From: BRYAN BUTCHER <[REDACTED]>
Sent: 23 August 2019 12:39
To: Maria Tomalova <[REDACTED]>
Subject: Abbots Lawn - BR/314/18

sheet 1 a of 6

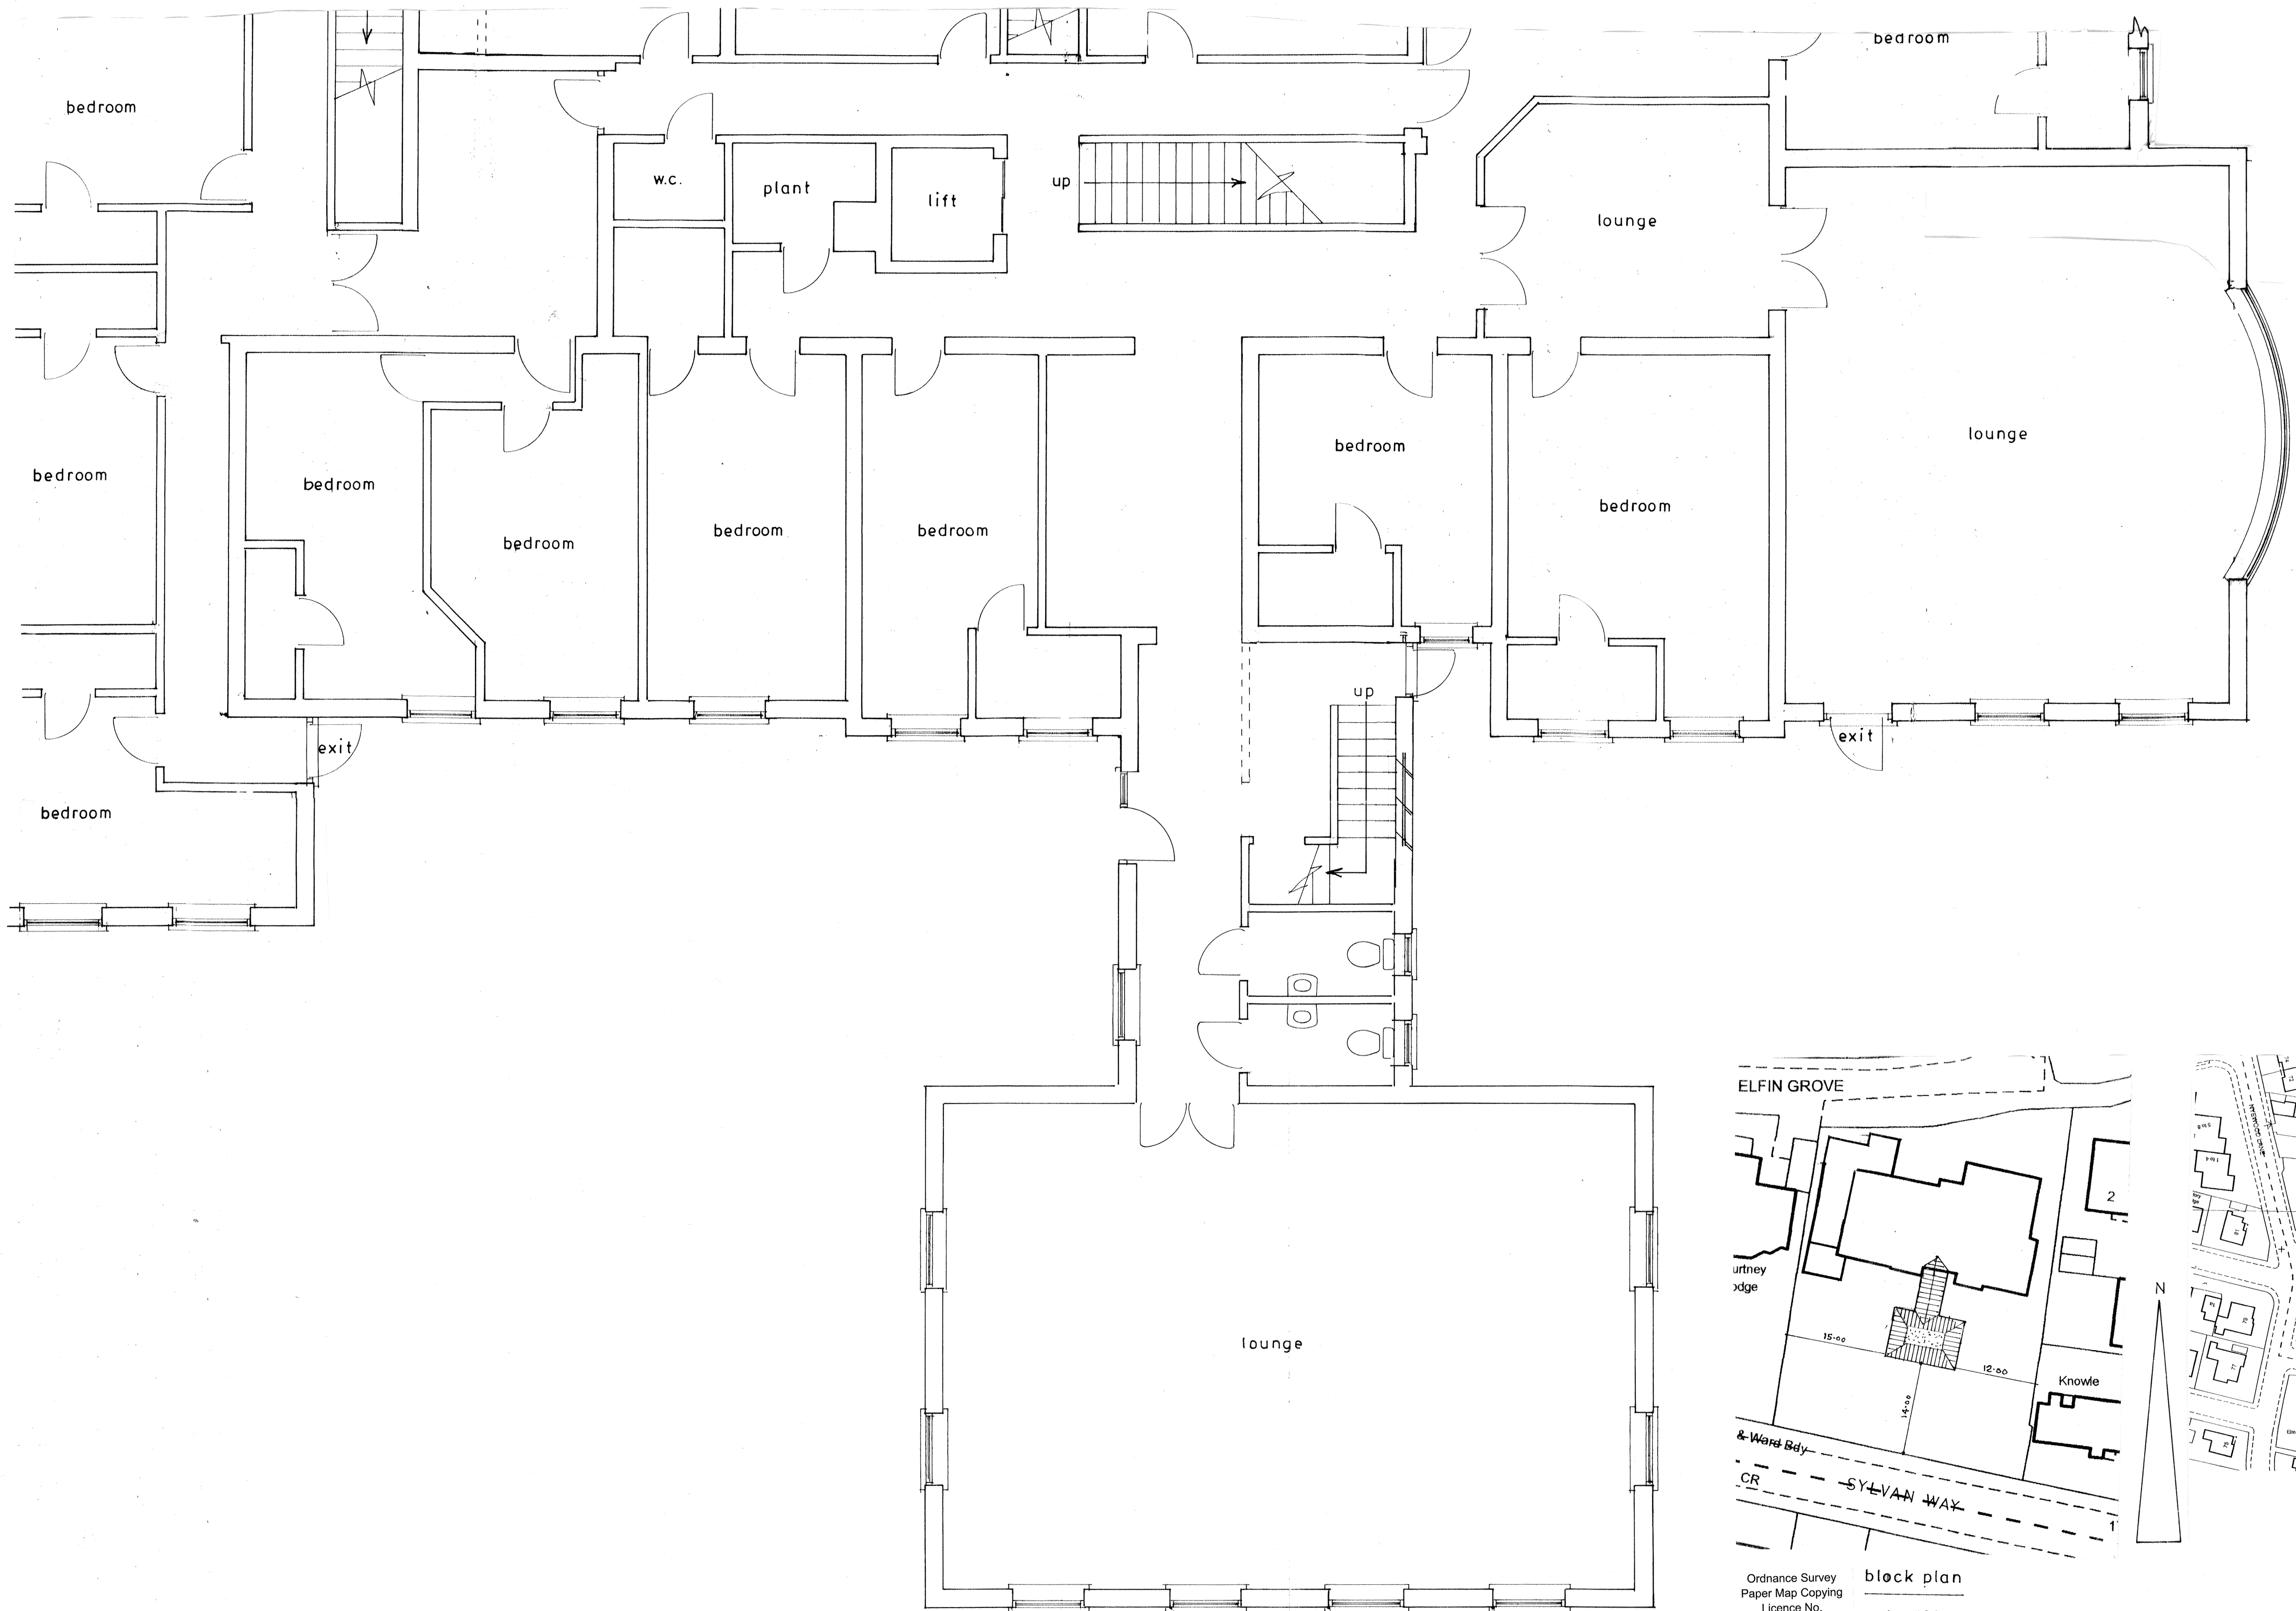
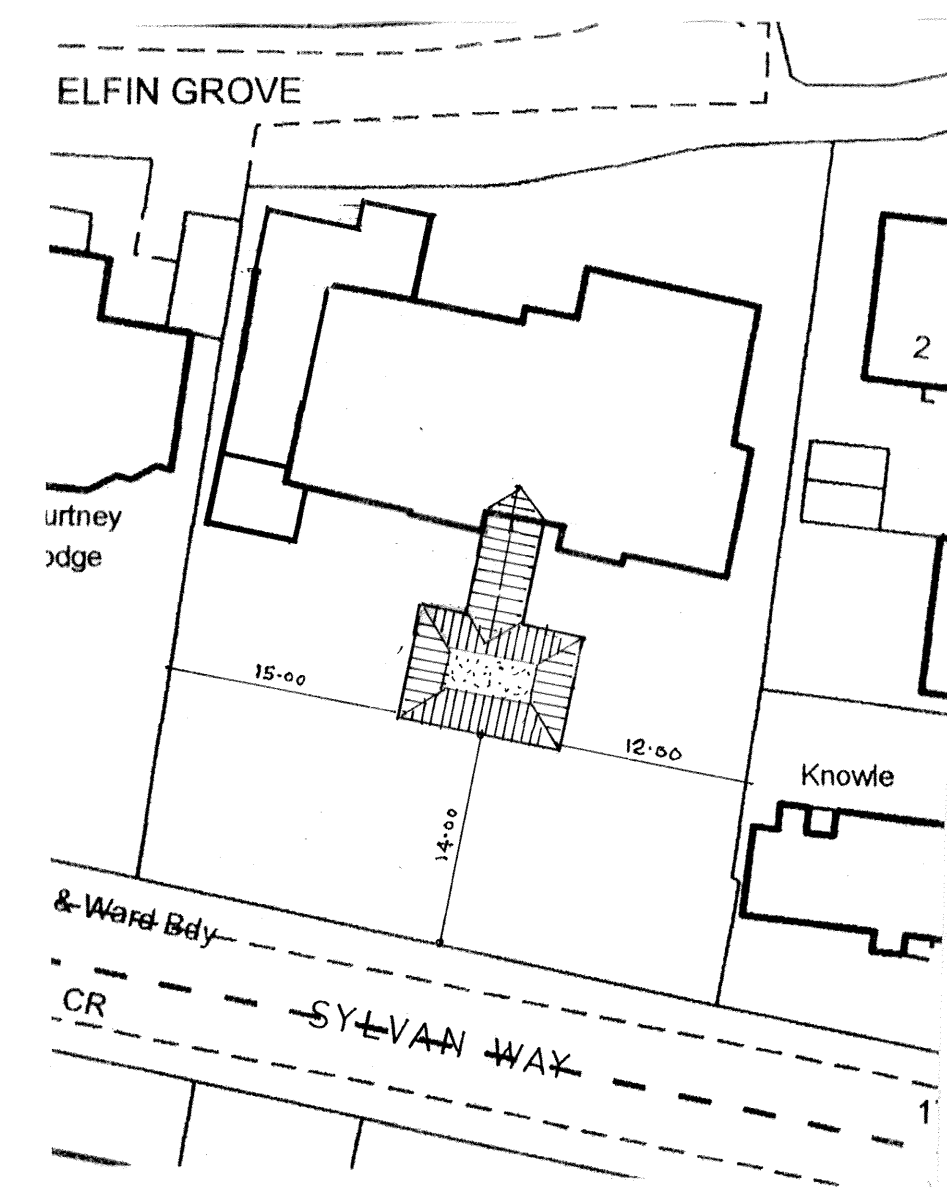
I have removed one of the parallel parking spaces to retain the Lime tree which is the only tree that he had concerns other than one in the south-east corner of the site which is not affected.

I have replaced this lost space in the new area in front of the lounge.

Mr Warwick didn't have issues removing the small Oak and Silver Birch although he was concerned with damage to the roots of the other trees during the lowering of ground levels.

I have therefore moved all the new spaces further away from the trees and still detailed the 'Grass Crete' blocks.
